From: Nia Russell [REDACTED]
Sent: 22 November 2017 16:38
To: Michael Eastham
Subject: Re: Amended plan of Salt Box site

Please could you send me an amended site plan of the Salt Box development showing an access road that will link up with the Rowan Park site to the south?

1 PROPOSED SITE PLAN
1 : 500

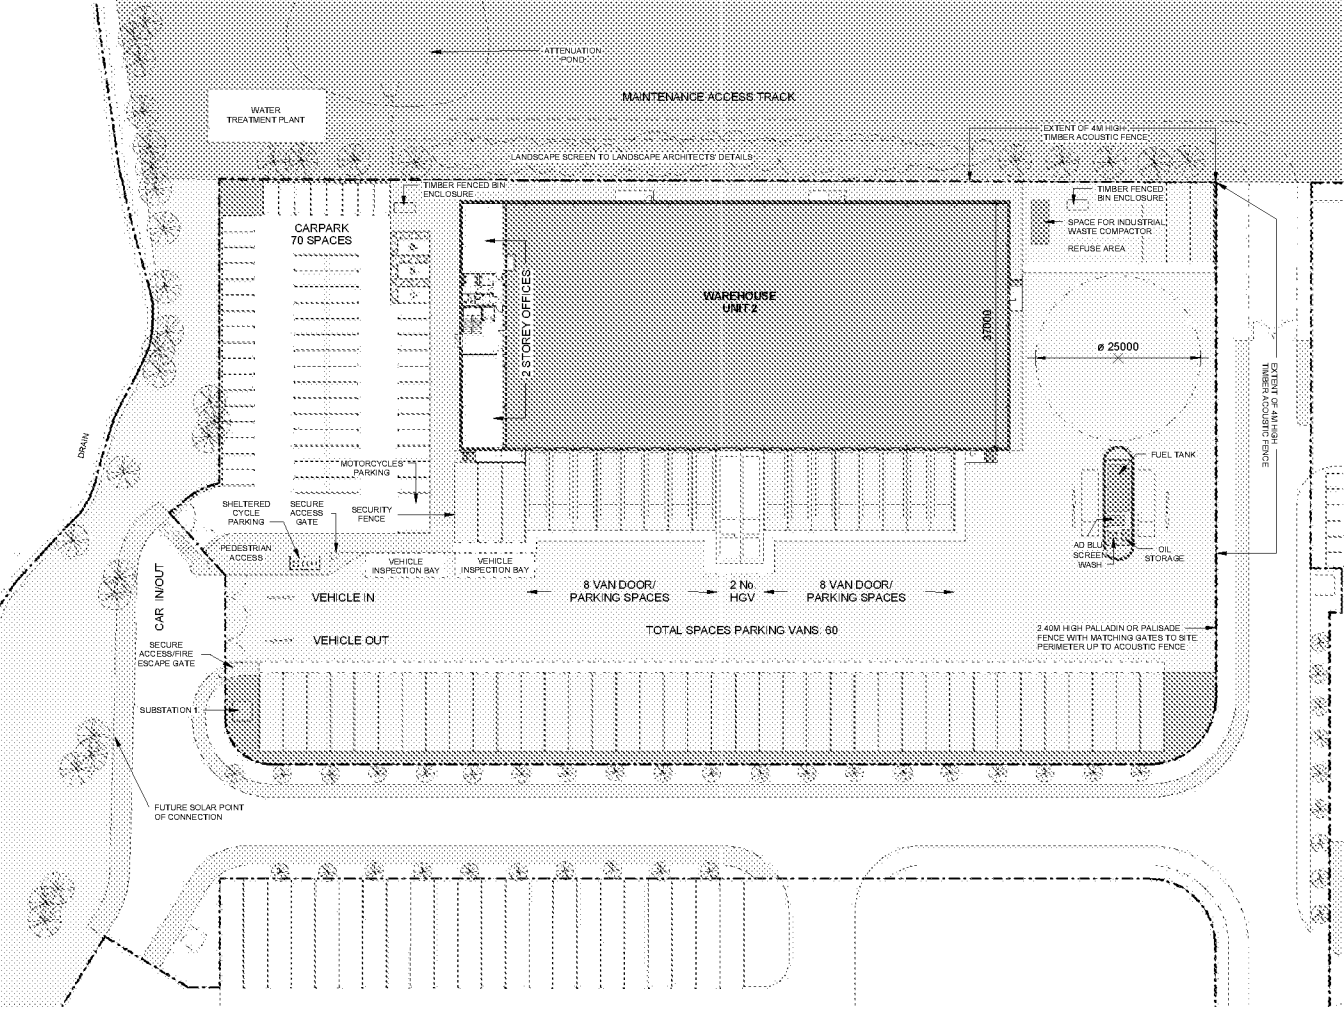
Both Salt Box and Rowan Park make up the strategic employment site in the emerging Local Plan and the current application needs to show potential access to the adjacent site.

Please see attached drawings as requested. I have asked our energy consultants to advise on the renewable energy point and will come back to you as soon as I can, but would comment that the report is only able to assess the units for which users and requirements are known which is why it concentrates on the 'full' area of the application and not the entire site at this stage.

There is an annotation shown on the drawings at the moment - do you mean showing the road link extended down to the red line boundary (as scribbled roughly on the attached)?
